**Consultation Response from KC,
Ecology Unit**

2024/90943 217, Barnsley Road, Denby Dale, Huddersfield, HD8 8TS

Erection of agricultural building

Date Responded: 28/06/2024

Annex
Baseline Map

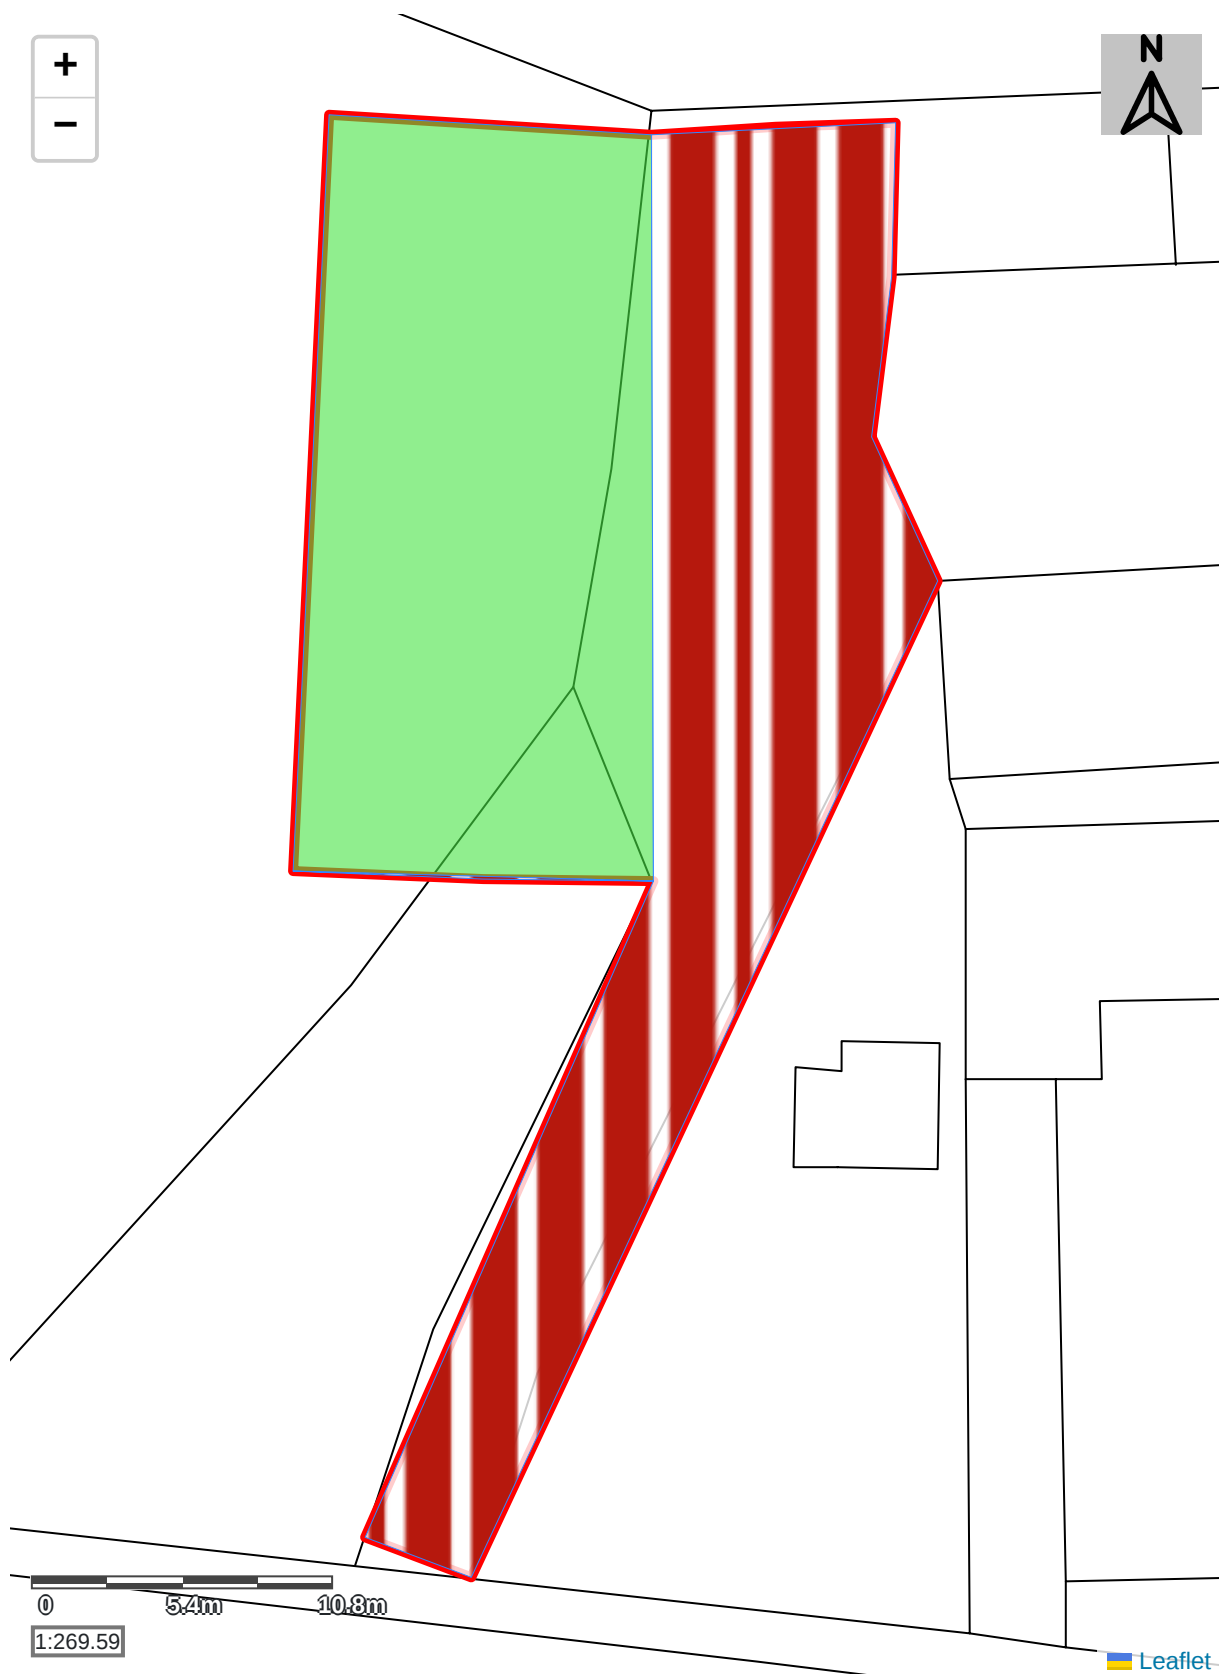
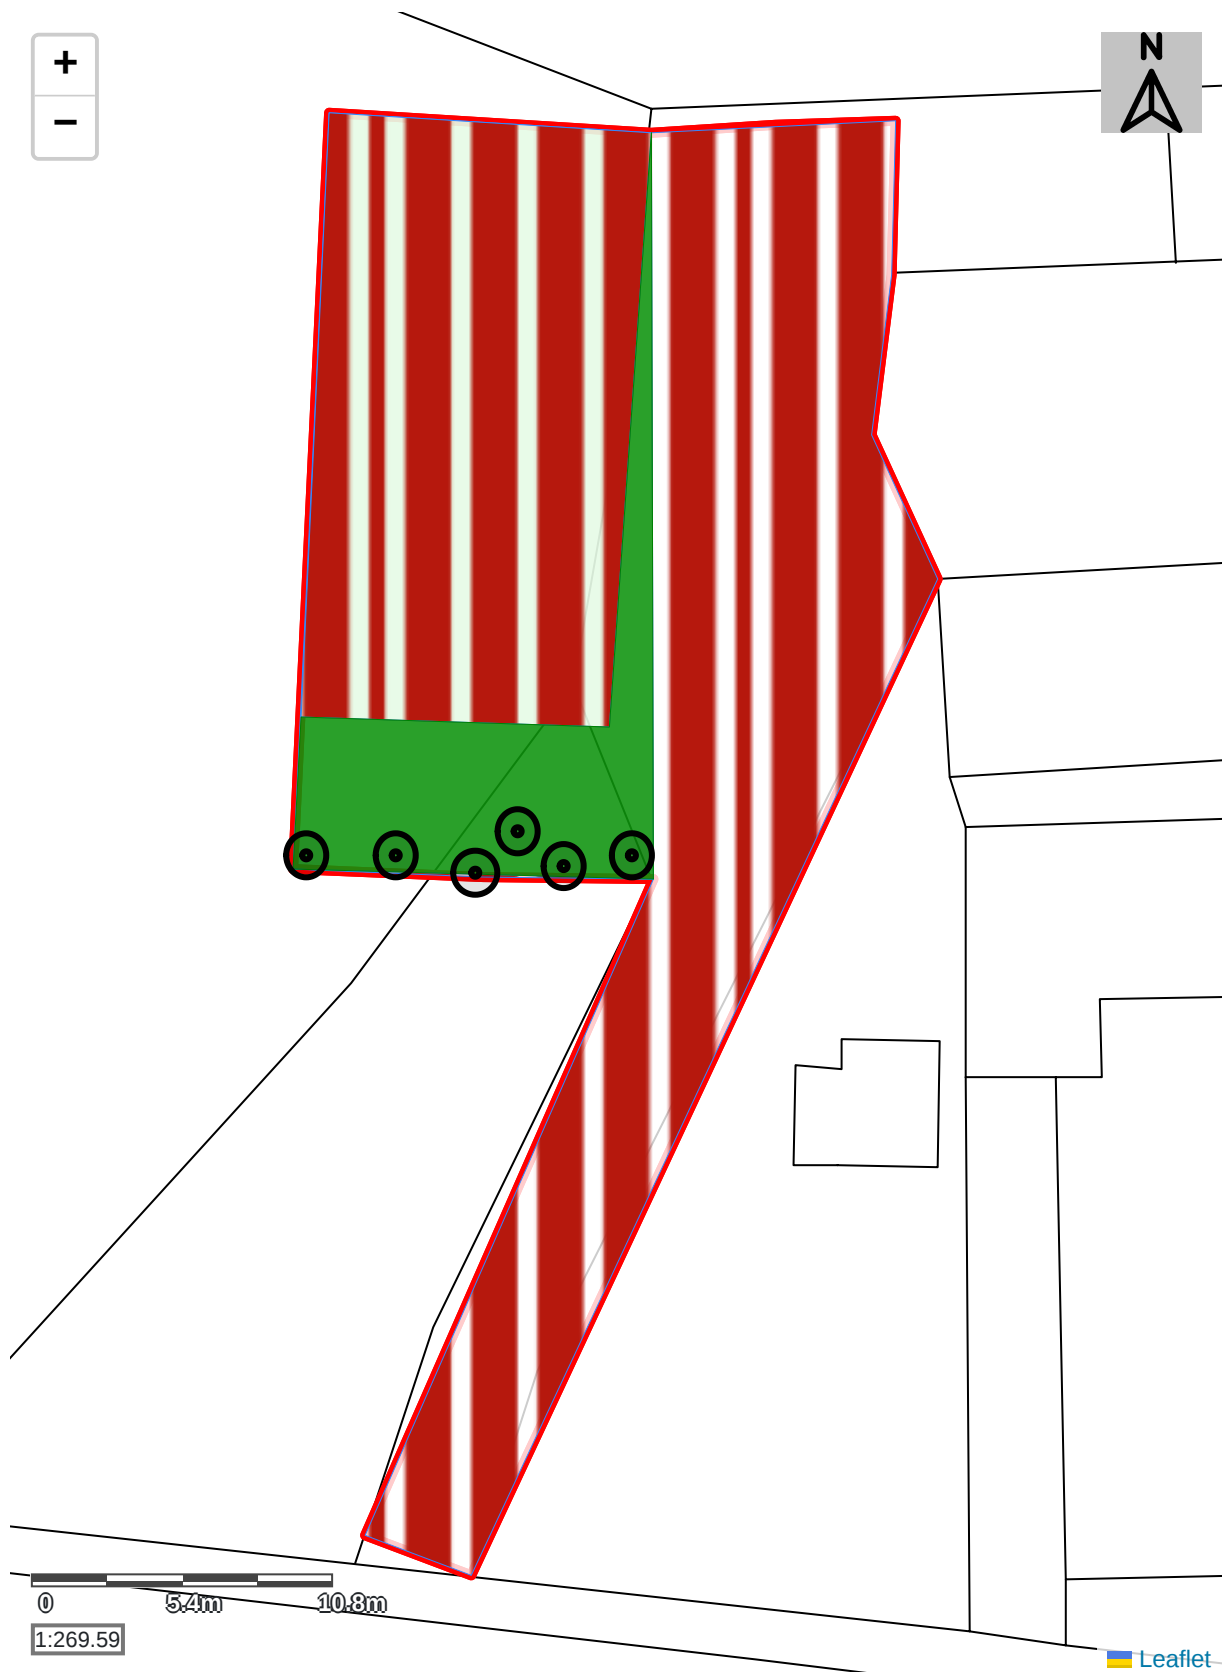
- No photographs submitted within the metric to provide evidence as to the baseline habitat types present.
- From aerial imagery, it looks as though the area of habitats present within the site could form part of modified grassland, and not grassland ley – photographic evidence should be provided to justify classifying it as this habitat type.
- The metric details that there will be no loss to any habitats at the site, when it is clear from the submitted proposals that the agricultural shed will directly overlay an area of grassland.

The errors in the metric should be rectified in order to ensure that the baseline value of the site is correct and address the comments with regards to the post development value of the site remaining the same.
